Prior Notification for Permitted Development

Schedule 2 Part 1 Class AA

Development: Prior approval under Schedule 2, Part 1, Class AA for the removal of existing roof, construction of new walls above existing walls to form new first floor walls and erection of new roof with a maximum height of 10.35m.

Location: The Haystack Sea Lane Ferring BN12 5EP

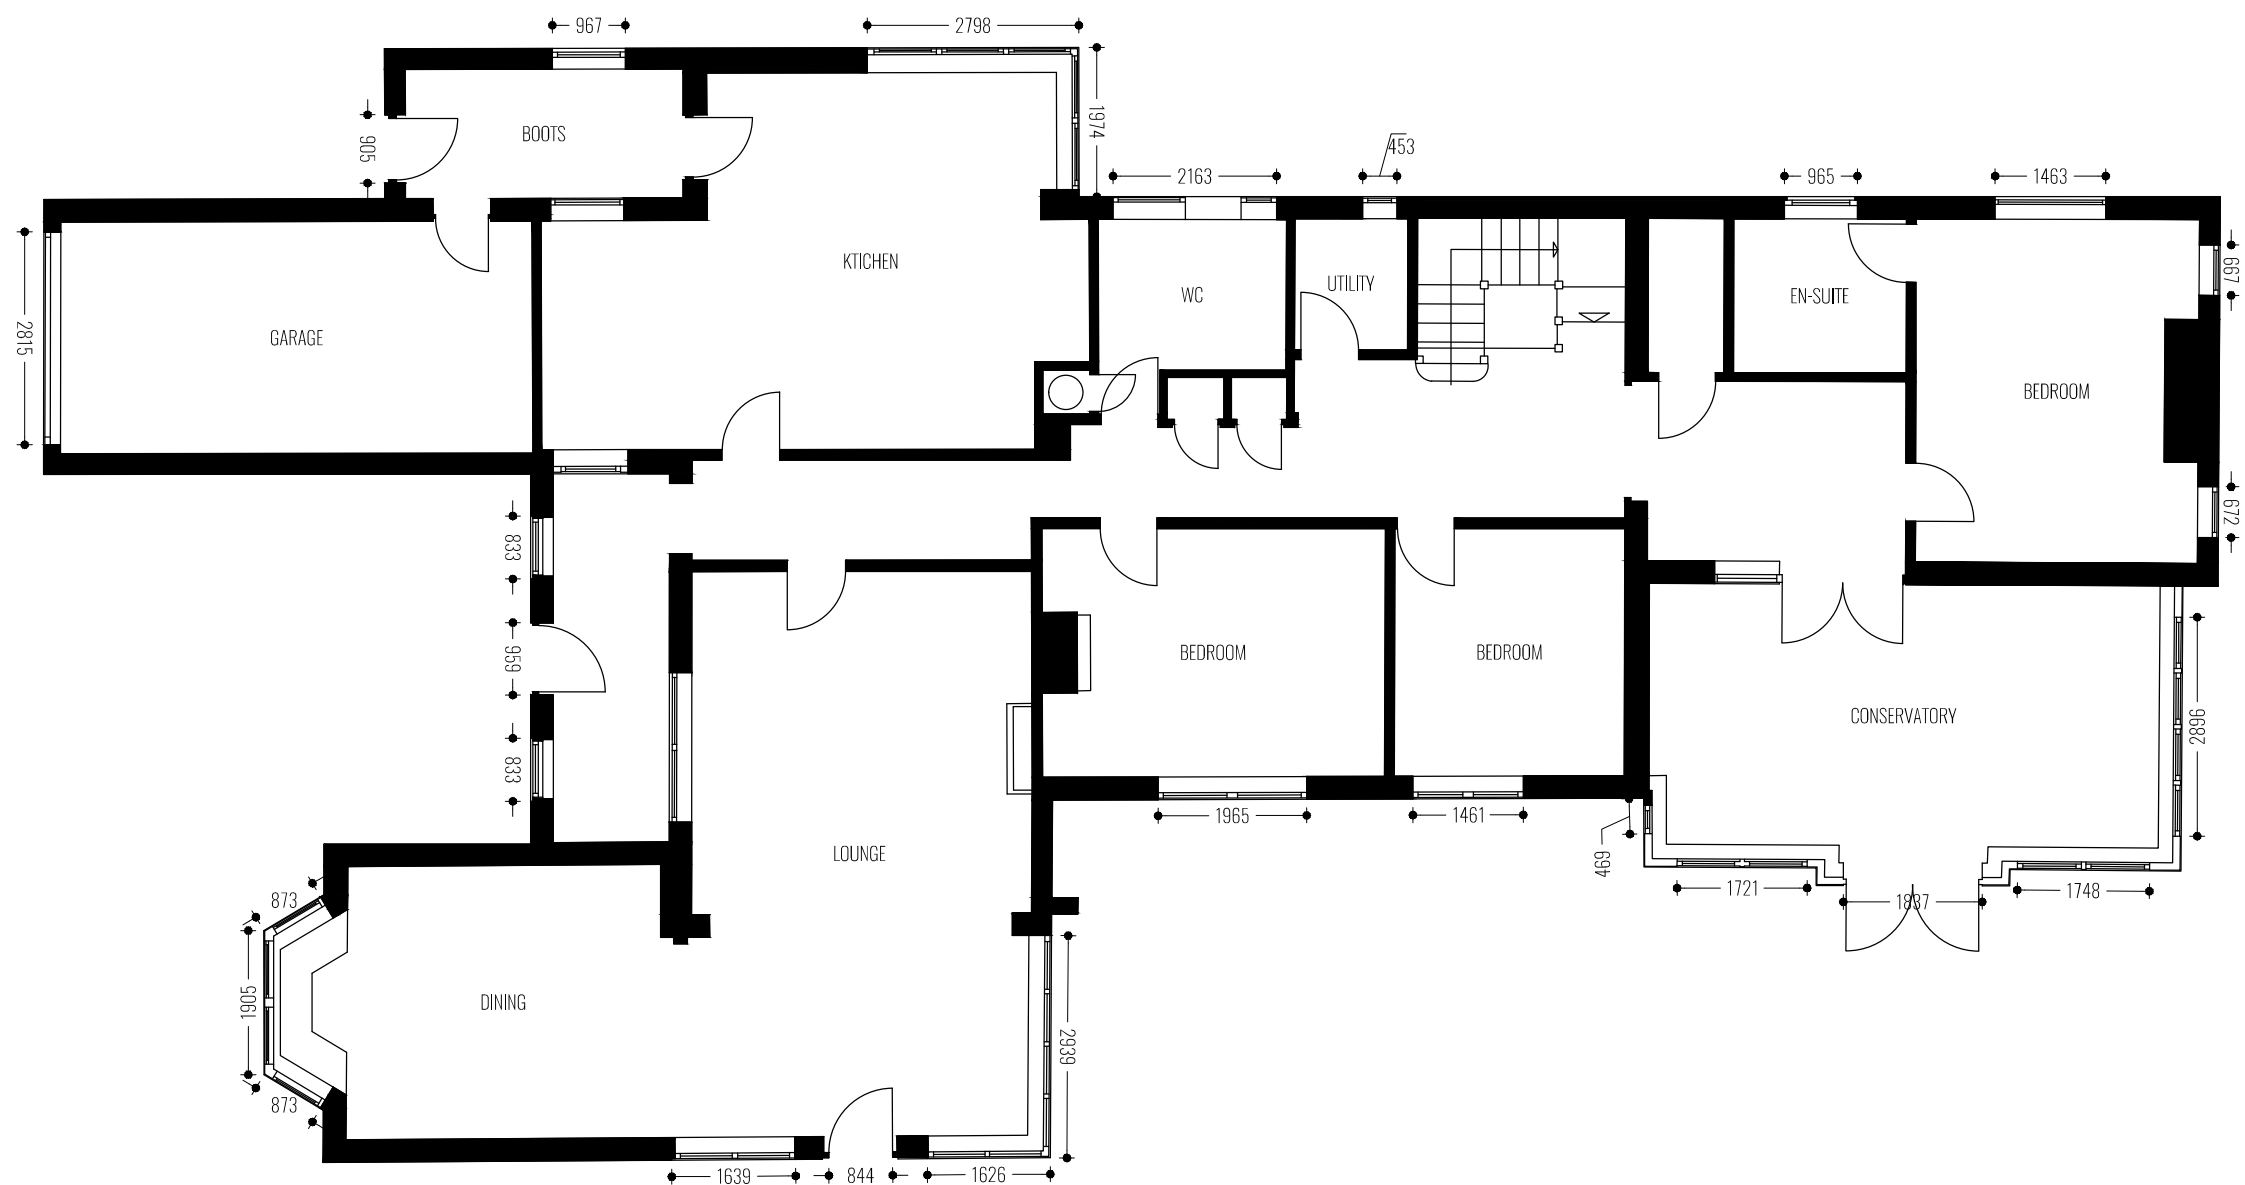
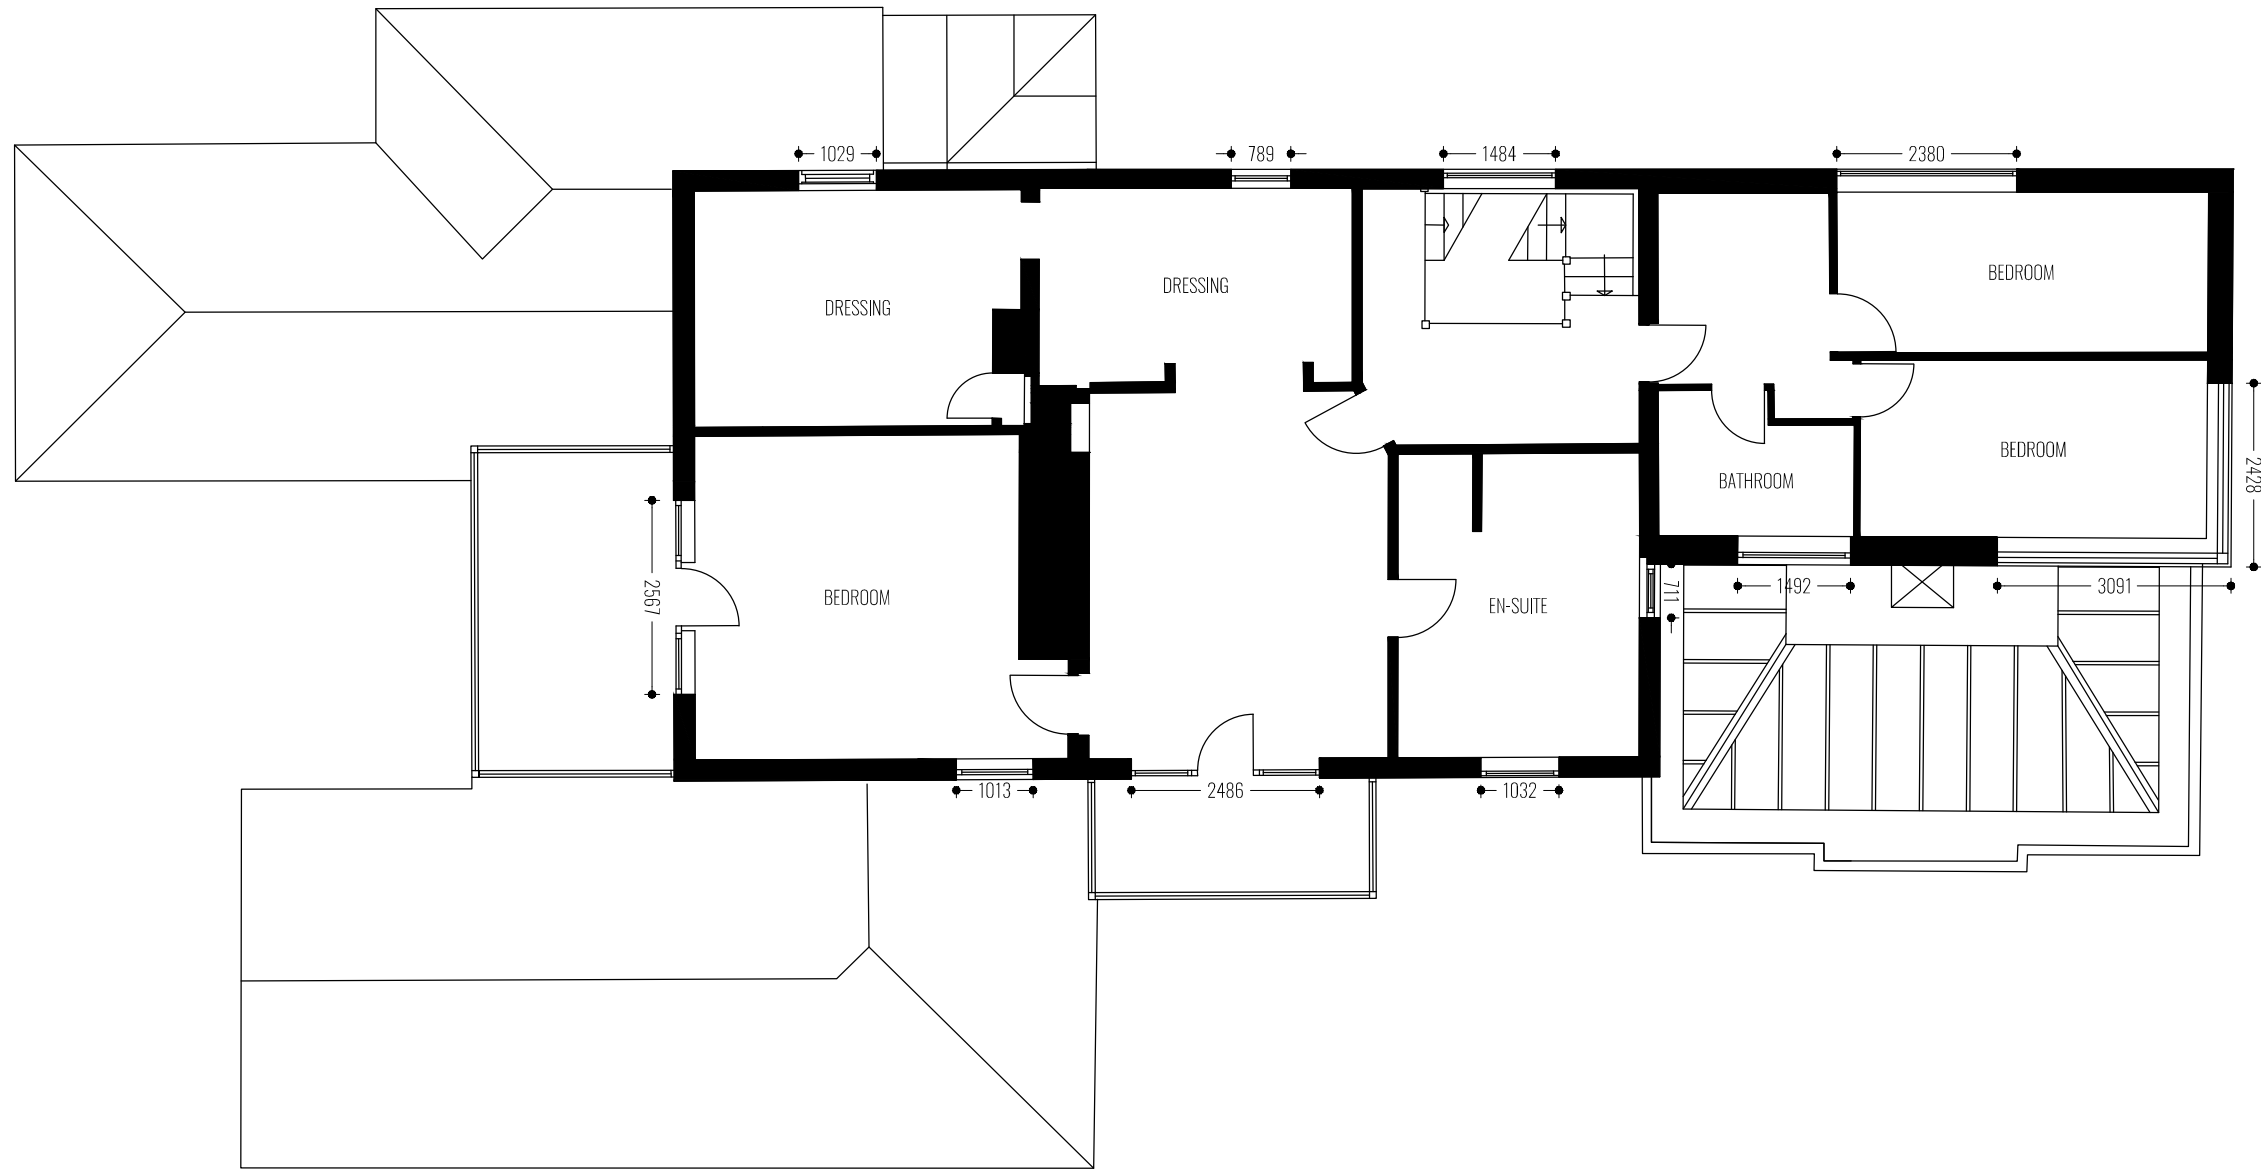
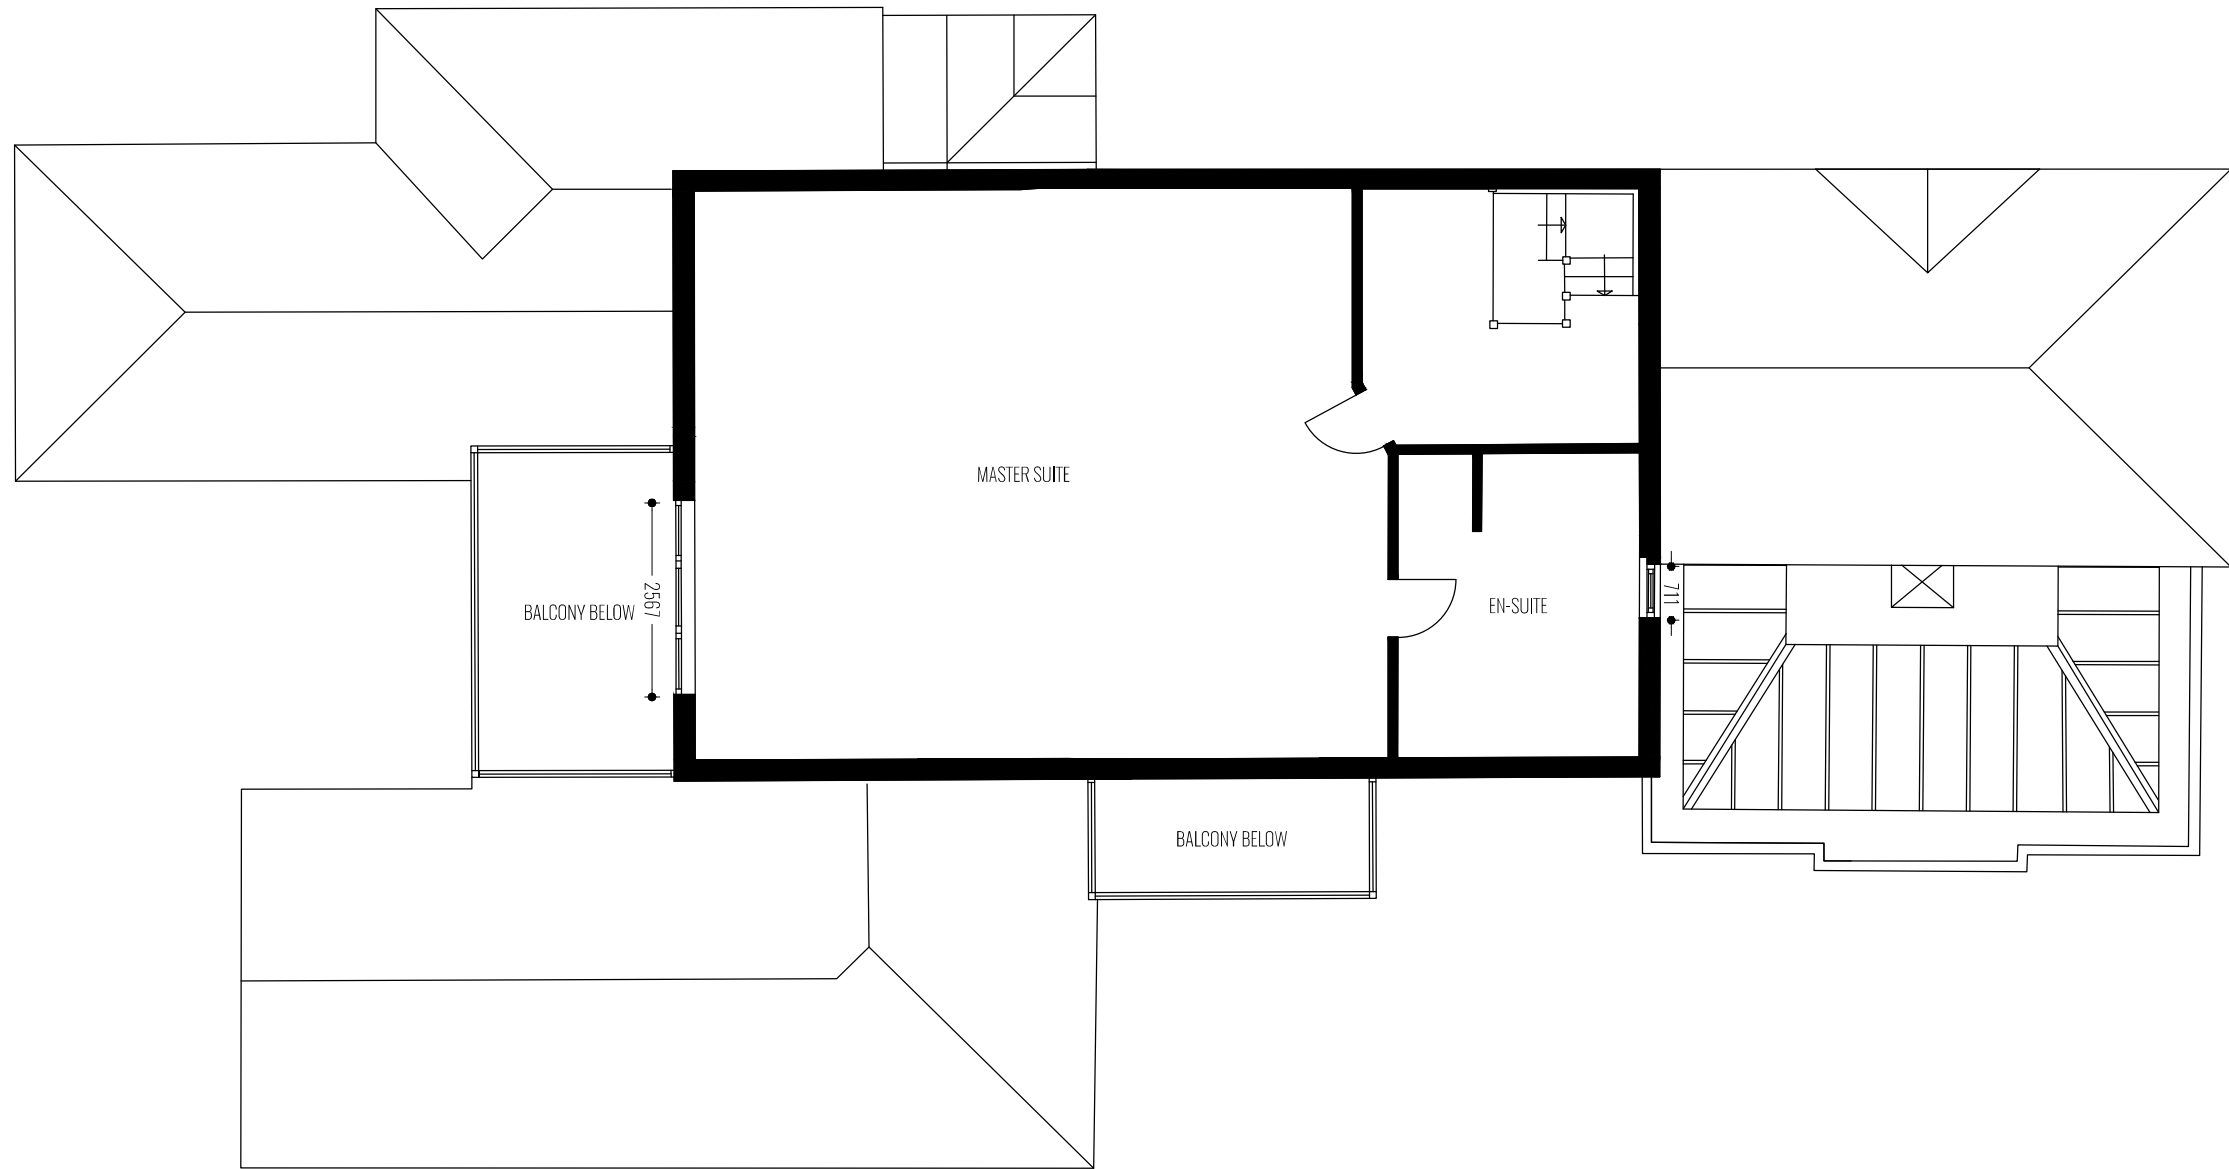
Please provide dimensions of the windows on the proposed floor plans or elevations.
